CITY OF ALBUQUERQUE

December 18, 2019

Re: Tramway Lofts
12711 Candelaria rd NE
Traffic Circulation Layout
Engineer's/Architect's Stamp 12-15-2019 (G23D015)

TCL SITE PLAN

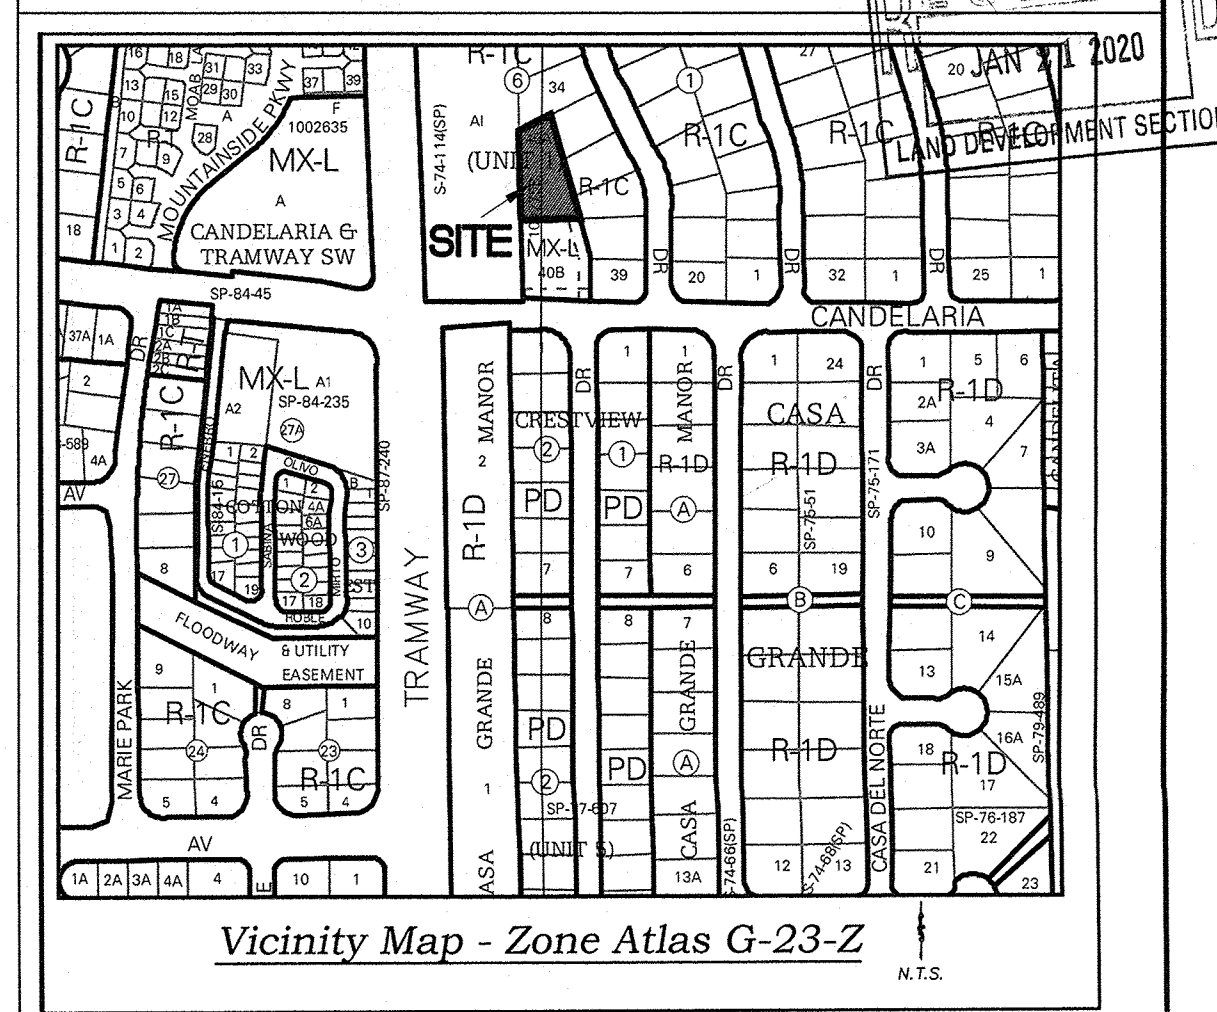
1. All bicycle racks shall be designed according to the following guidelines:
 - a. The rack shall be a minimum 30 inches tall and 18 inches wide.
 - b. The bicycle frame shall be supported horizontally at two or more places. Comb/toaster racks are not allowed.

- c. The rack shall be designed to support the bicycle in an upright position. See the IDO for additional information.
 - d. The rack allows varying bicycle frame sizes and styles to be attached.

- e. The user is not required to lift the bicycle onto the bicycle rack.
 - f. Each bicycle parking space is accessible without moving another bicycle.

2. Bicycle racks shall be sturdy and anchored to a concrete pad.
3. A 1-foot clear zone around the bicycle parking stall shall be provided.
4. Bicycle parking spaces shall be at least 6 feet long and 2 feet wide.

5. Per the IDO, a 6 ft. wide ADA accessible pedestrian pathway is required from the public sidewalk to the building entrances. Please clearly show this pathway and provide details.

6. Per DPM, a 6 ft. wide ADA accessible pedestrian pathway is required from the ADA parking stall access aisles to the building entrances. Please clearly show this pathway and provide details.(the accessible space has a curb that is not flushed with sidewalk)
